Objector	Objection	Comment
Kathy Smith 20 Blackwell Road, Woy Woy NSW 2256	The extension of time for implementing the development approval or modification of the approval.	Gosford City Council has confirmed in its letter (19 August 2015 as attached) that the development has commenced. No extension of time is necessary or has been sought in this instance.
	Does not comply with Gosford LEP 2014 with respect to FSR.	While the relevant FSR controls in the Gosford LEP are cited in the Statement of Environmental Effects, they do not apply to this Project Application being a Part 3A assessment. Nonetheless, while the proposed FSR exceeds the Gosford LEP, it does meet the aims of the FSR as specified in cl. 4.4 of the LEP. That is, the proposal seeks to maximise the efficient use of floor space, while generally maintaining the overall building envelope and ensuring that the new development reflects the desired character of the locality in which it is located.

Objector	Objection	Comment
		upper levels of the building are shown in the accompanying elevations and sections (see drawing DA201 and 740, CD Architects January 2016). The proposed building height is lower than the approved developm

DA SUBMISSION		
Job no.	Drawing no.	Rev.
J15304	DA 740	C
Drawn by	Checked by	Date
PY	ZC	NOV 2015

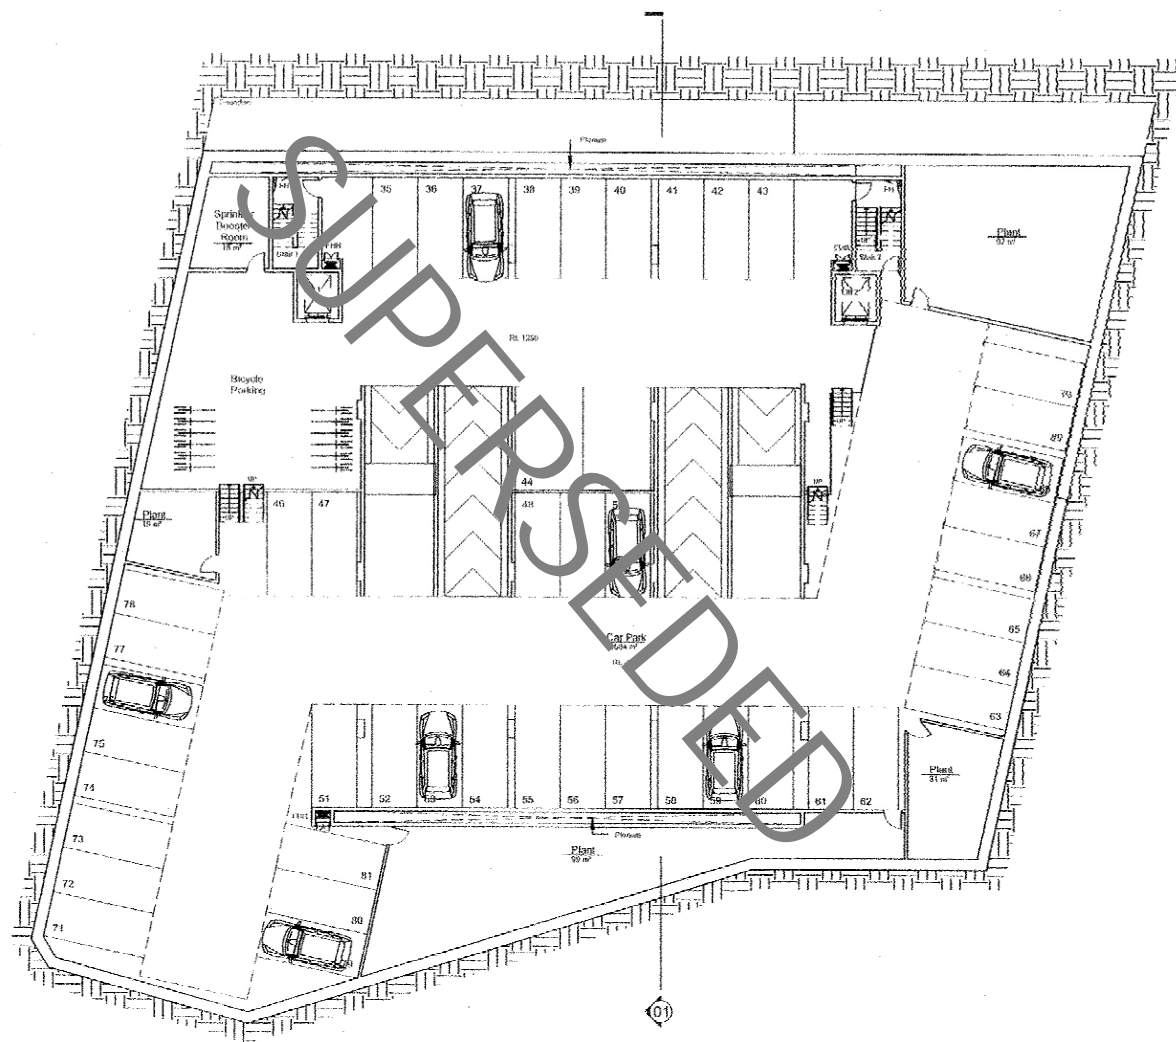
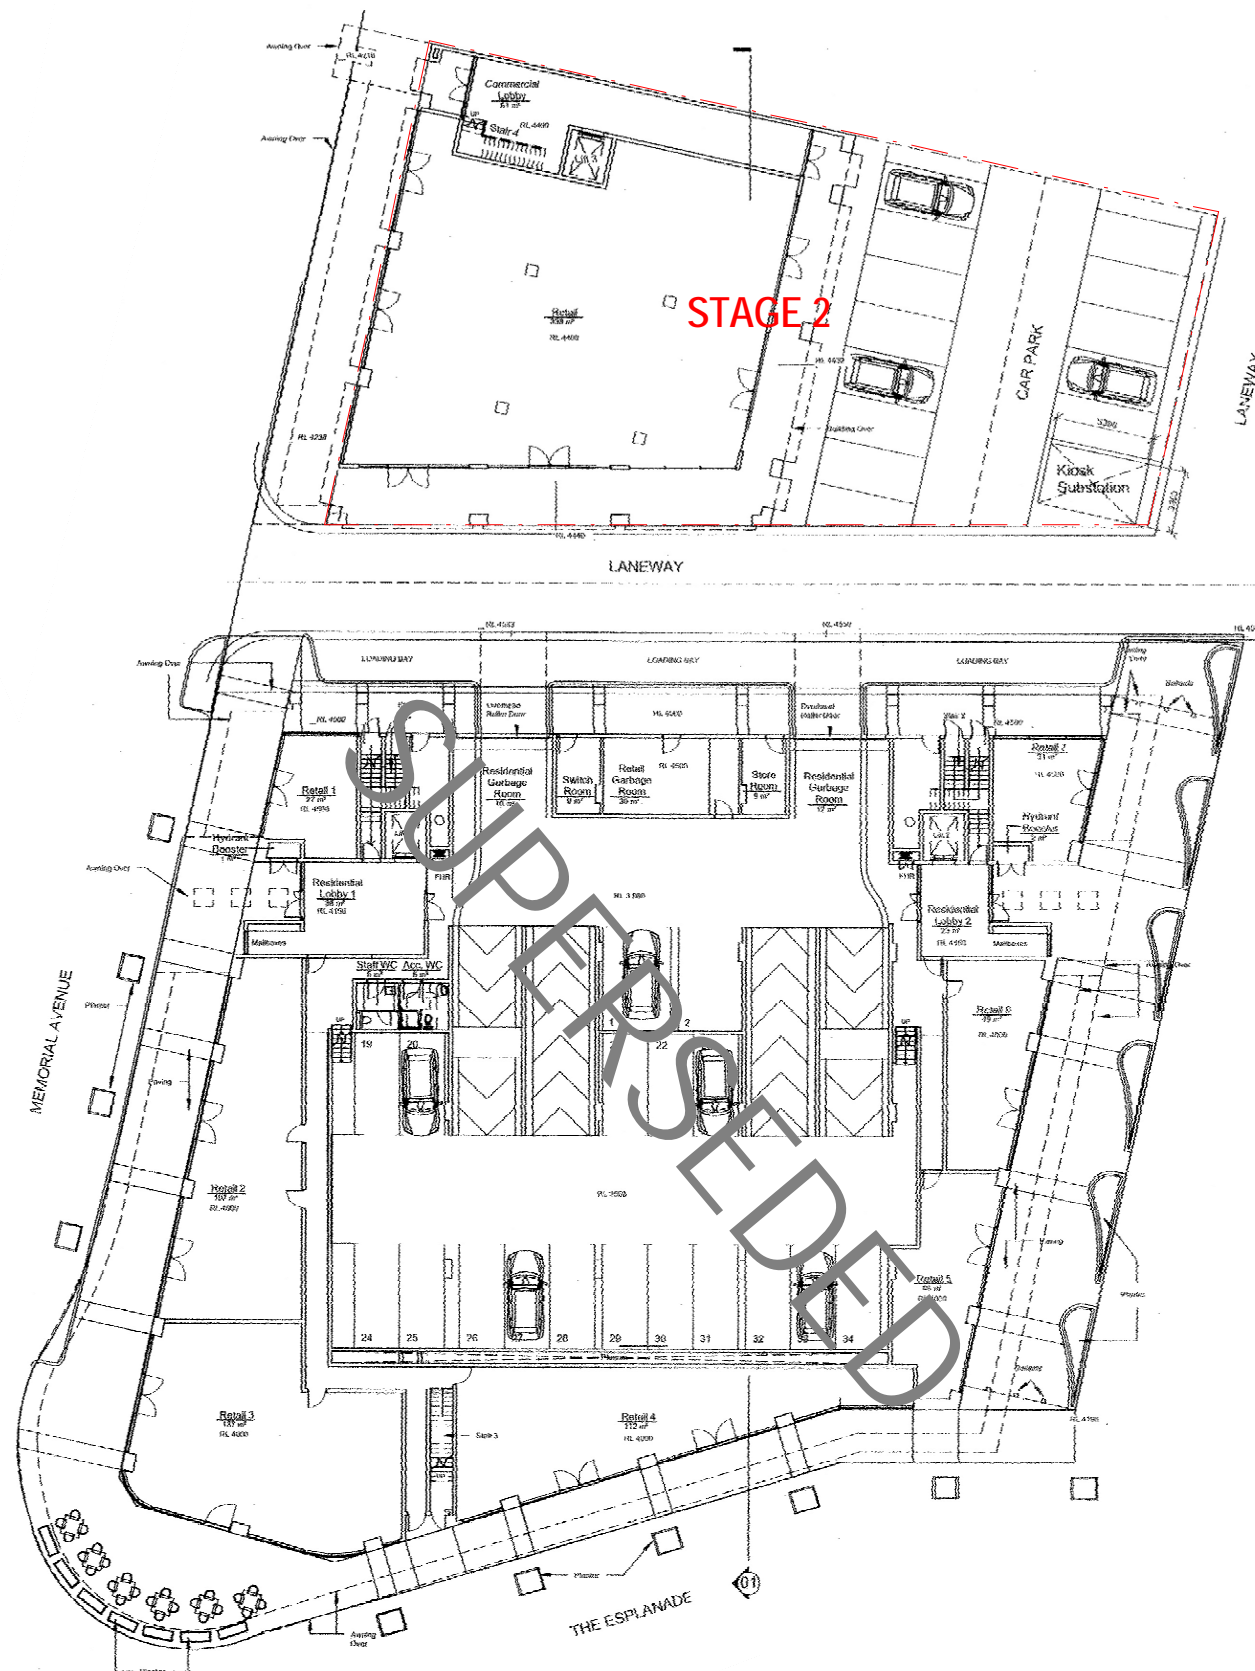
Exceeds maximum height in accordance with the Gosford LEP 2014.	While the relevant height controls in the Gosford LEP are cited in the Statement of Environmental Effects, they do not apply to this Project Application being a Part 3A assessment. Where the proposed height exceeds the development standards of the Gosford LEP, meets the aims of the height standard as specified in cl.4.3 of the LEP. That is, the proposal responds to the desired future character of Ettalong which is consistent with the Gosford LEP. The proposed height is suitable as it: • Will provide a suitable transition in height and mass from the neighbouring 9-storey 'Outrigger Building' to surrounding low level developments. • Presents a 'pedestrian scale' (3-storeys) along The Esplanade and Memorial Avenue with subsequent storeys being setback from surrounding streets. The scale transition in the upper levels of the building are shown in the accompanying elevations and sections (see drawing DA201 and 740, CD Architects January 2016).

Objector	Objection	Comment
		The proposed building height is lower than the approved development; the height for the existing approval is 23.5m and the proposed height is 22.4m. The proposed height is reduced by 1.1m.
	Creates overshadowing.	Compared to the approved development, the proposed building bulk and height will not result in any significant increase in overshadowing of neighbouring properties or areas of public open space. Total shadow volumes increase by 68m², 61m² and 70m² at 9am, 12 noon and 3pm on 21 June respectively (drawing number DA 600, CD Architects). Shadows from the development would roughly fall within the shadow cast by the approved development. While there is some overshadowing from the development, it is not considered significant in its impact as Ettalong Beach. This beach covers a large area and the overshadowed area is relatively small. Issues associated with overshadowing are typically to do with private open space (i.e. open areas within residential premises). Much of the building shadow would fall on public areas; such as The Esplanade, Memorial Avenue and part of Ettalong Beach. Neighbouring developments that would experience overshadowing are hospitality premises; that is, the Mantra Hotel and Ettalong Beach Motel. In all of these areas, private open space would not be adversely affected.
